From: Cllr. Andy Cooper
Sent: 09 November 2018 09:51
To: Colin Chandler
Cc: Planning.Responses; [REDACTED] Karl Roberts; Cllr. Paul Bicknell; Cllr. Dudley Wensley
Subject: Re: 53 Mill Road Avenue

Re: **53 Mill Road Avenue, BN16 4HX**

Applications: **A/128/18/CLE and A/132/18/HH**

REAR ELEVATION
East

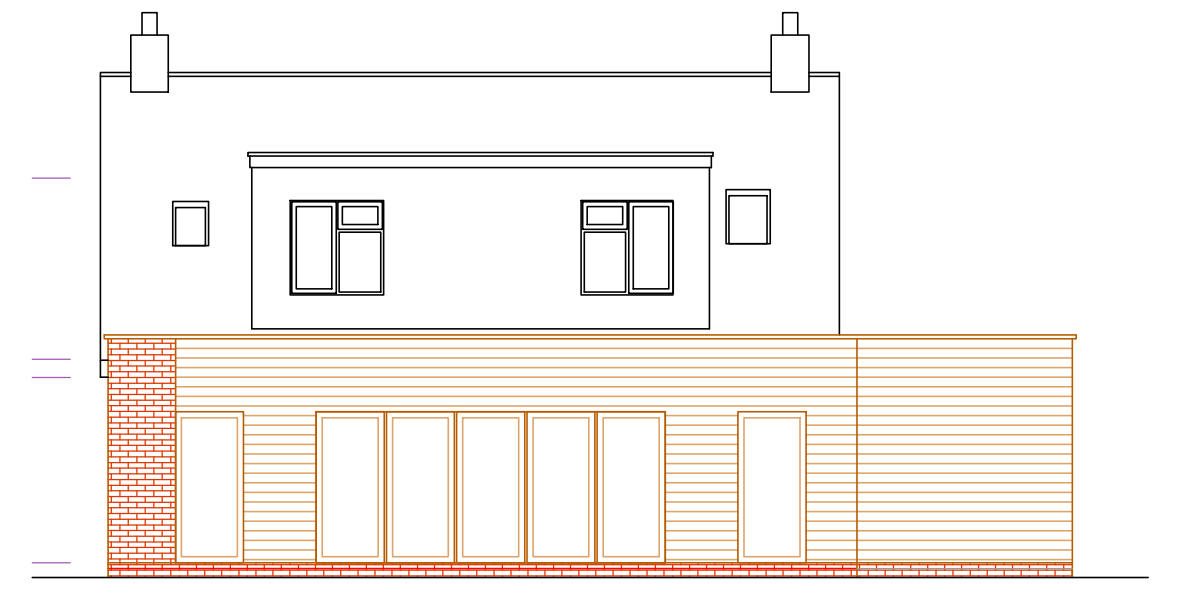
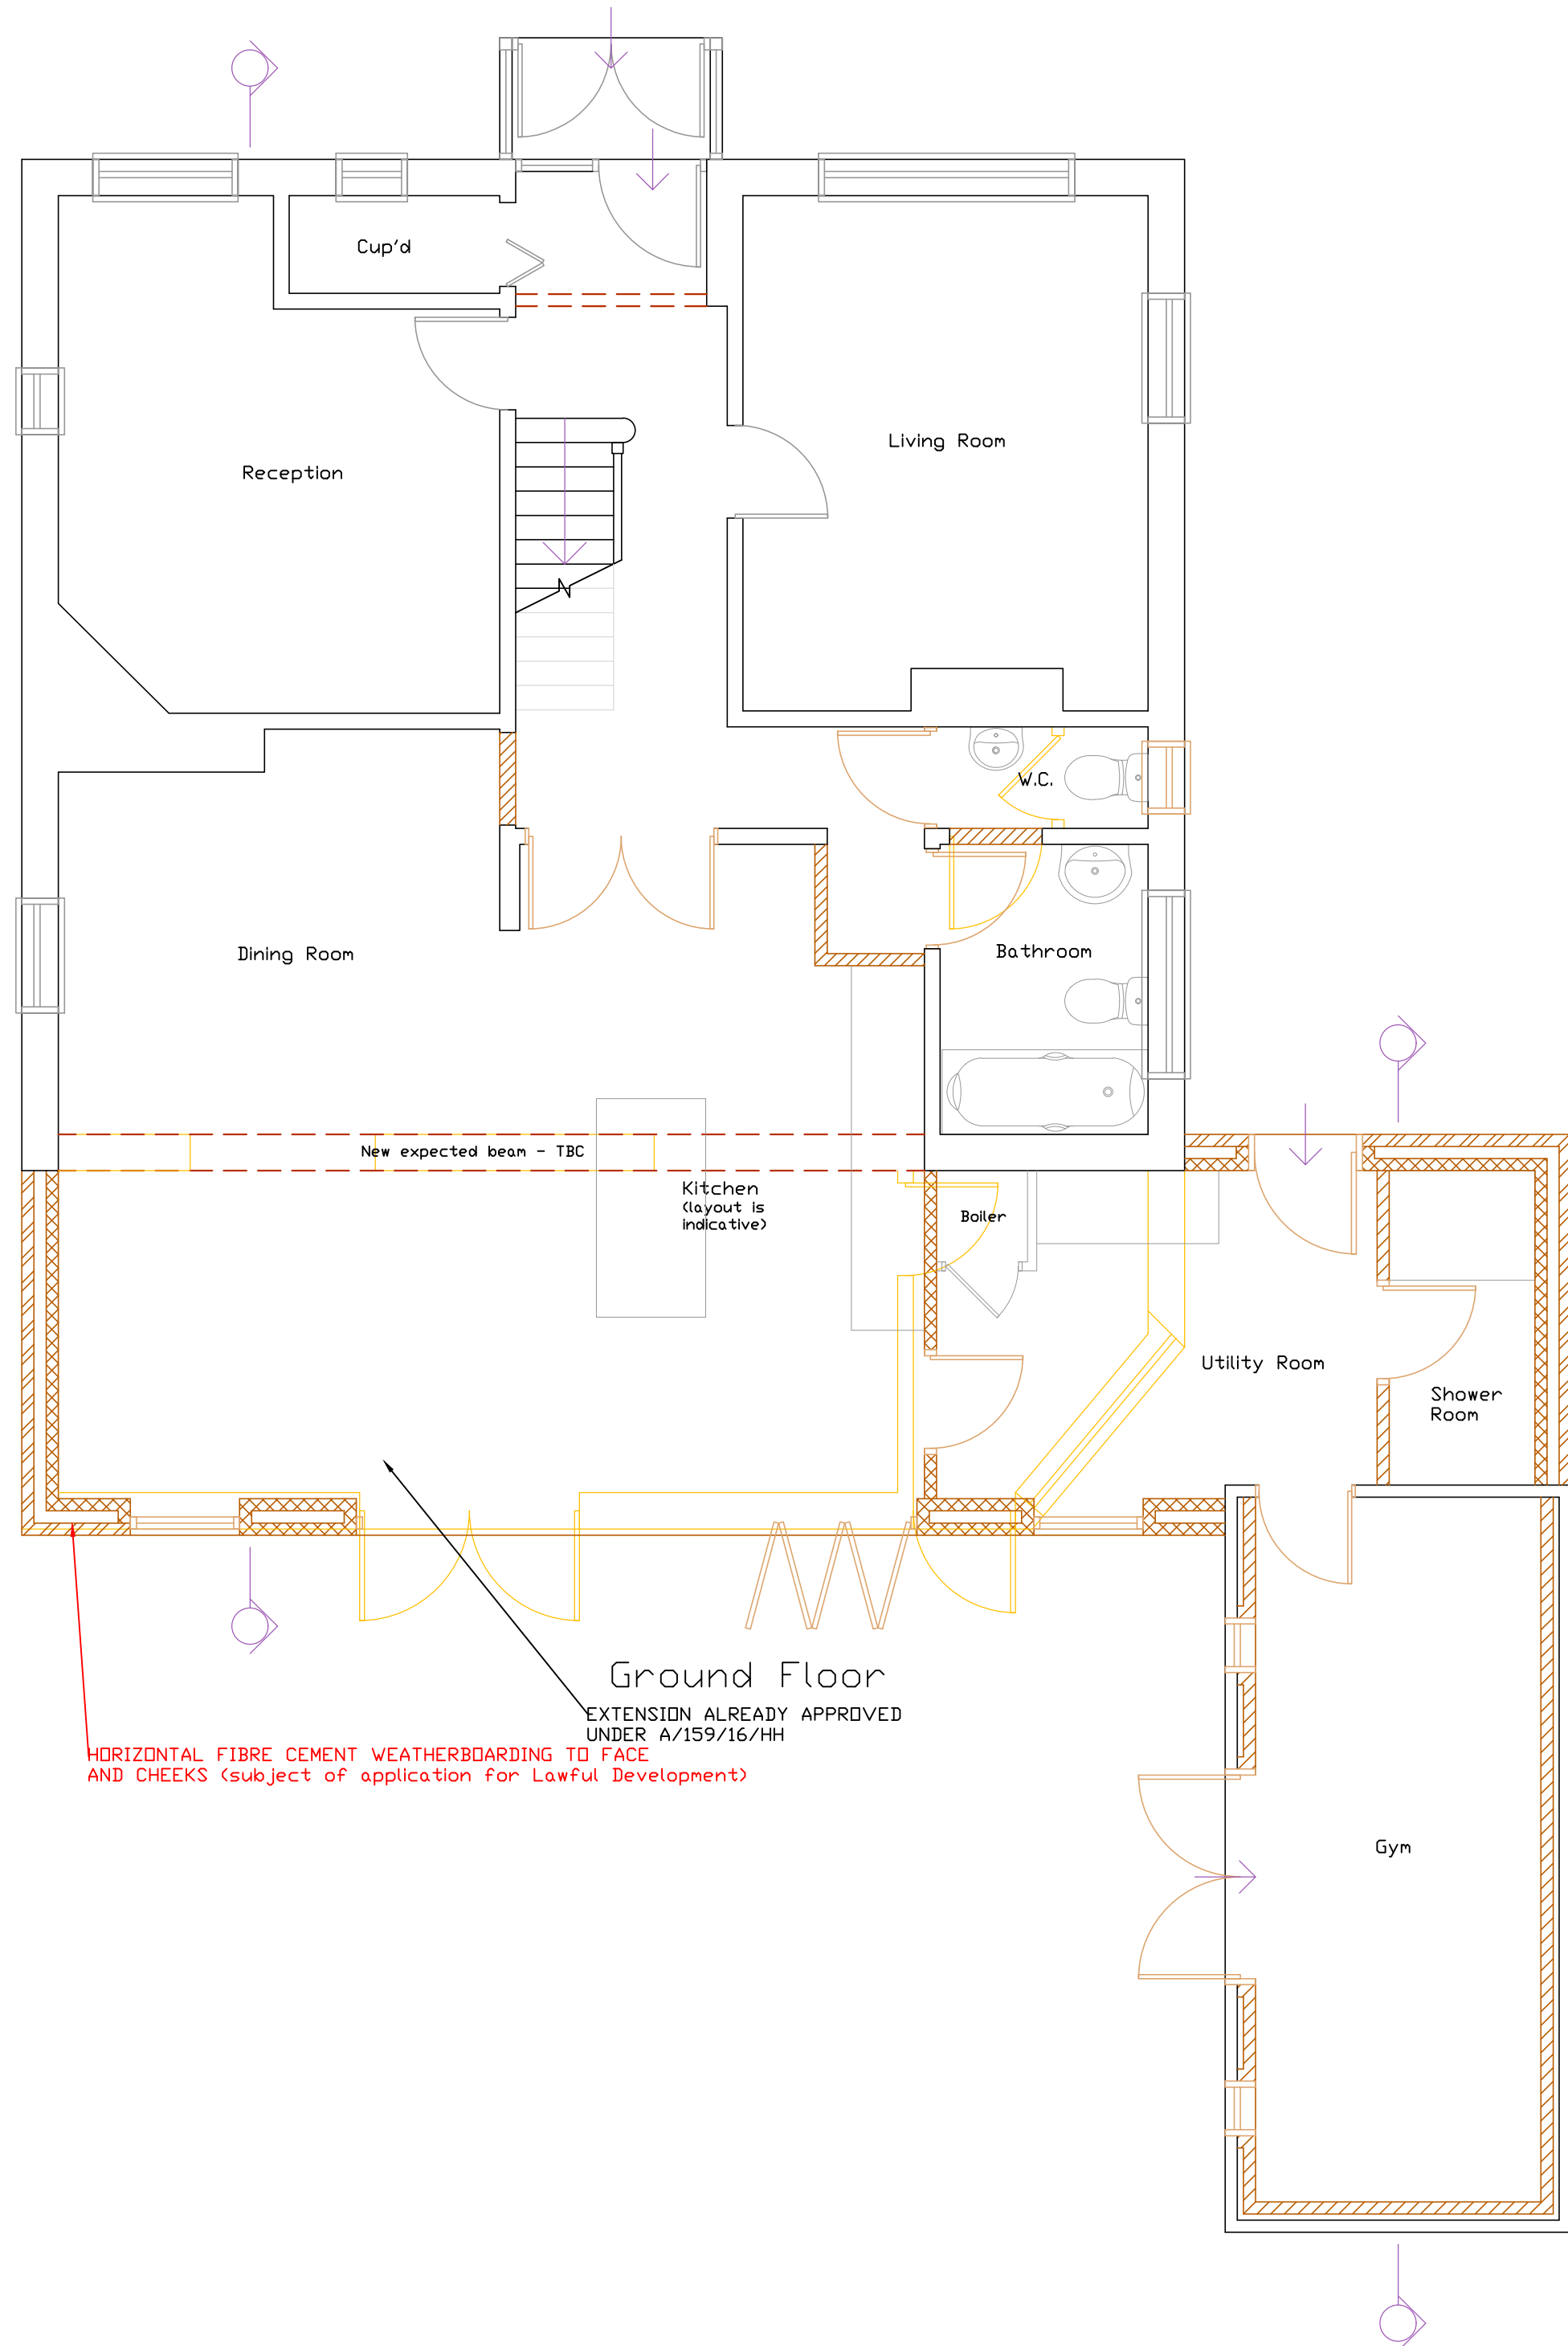
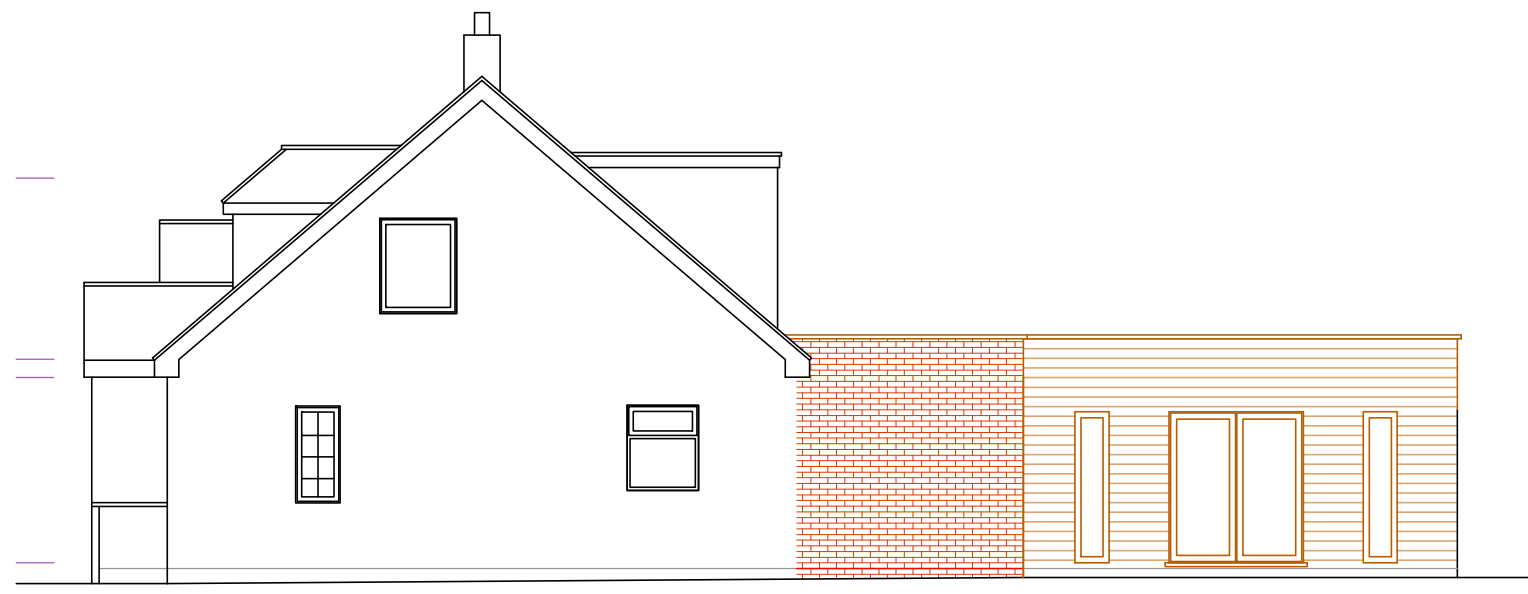
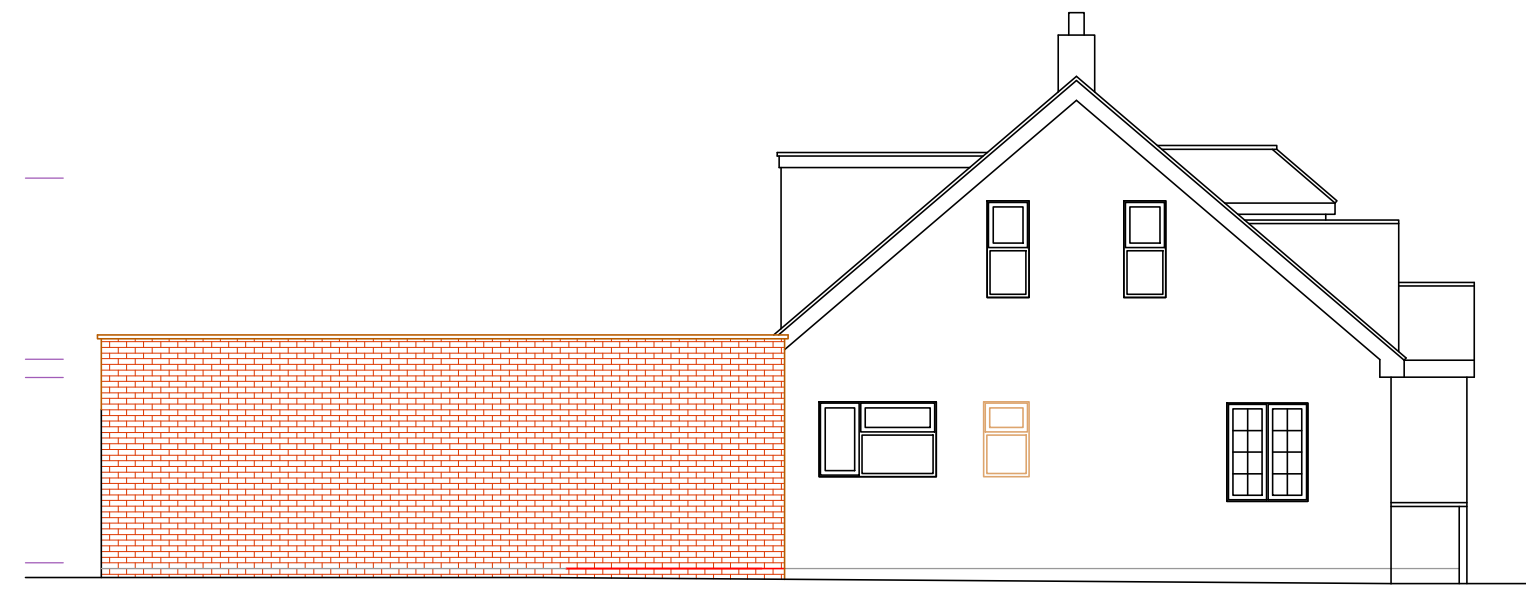
The Parish Council (PC) on 30/10 resolved to raise no objections to the current 3 applications at the above site. Regrettably, we could not attend that meeting but from neighbour feedback we remain concerned that material considerations were not taken on board. Our primary concern is the proposed use of horizontal cladding (mock timber) on the recently extended dormer.

The PC's decision is contrary to their previous finding on application A/36/16/HH that included the use of the same type cladding in a vertical format on a proposed two storey rear extension when the PC resolved to object on the grounds that: *"...the materials proposed are not in keeping with the the surrounding area and are therefore not in accordance with Neighbourhood Plan Policy HD4: Materials."*

In turn, the application was refused by Arun District Council with the officer report noting that the cladding was: *"...not considered well integrated with the host dwelling...and results in a proposal which is unsympathetic to the character of the original dwelling, contrary to Policy DEV19(i) and GEN7(ii) of the Arun District Plan"*

In relation to the consideration of application **A/128/18/CLE**, account does not appear to have been taken by the PC of the Government guidance dealing with permitted development rights that states: *"the face and sides of a dormer window should be finished using materials that give a similar visual appearance to existing house. So the materials used for facing a dormer should appear to be of similar colour and design to the materials used in the main roof of the house when viewed from ground level. Window frames should also be similar to those in the existing house in terms of their colour and overall shape."*

Both those decisions make it clear that weatherboarding and zinc (as examples) are not *similar* or appropriate materials in the context of traditional tiled roofs, as exists on and about No.53, to attract the benefit of Permitted Development.

We see that since making our previous representations and the PC's consideration, two sets of French doors and two windows have now been installed and finished in grey - a colour that does not accord with other existing windows. That work also now appears to mean the test of lawfulness should fail, aside from the fact the openings bear little resemblance to that shown on the submitted drawing.

To be consistent and noting the particular restrictions on roof level changes, we believe that application **A/132/18/HH** for planning permission, (no doubt submitted in anticipation of A/128/18/CLE being refused) to clad the newly extended dormer at No.53 with similar cladding to that which was previously rejected should also be refused. The impact on the character and appearance of the surrounding area, as well as the No.53 itself, is demonstrated in the photo taken from our own similar dormer. (No.53, is on the left, showing their dormer before recent additions.) This application remains incomplete without a proposed rear elevation of the dormer.

As previously stated, there is a perfectly acceptable alternative to 'dress' the dormer with traditional tile hanging, subject to suitable *similar* colour choice.
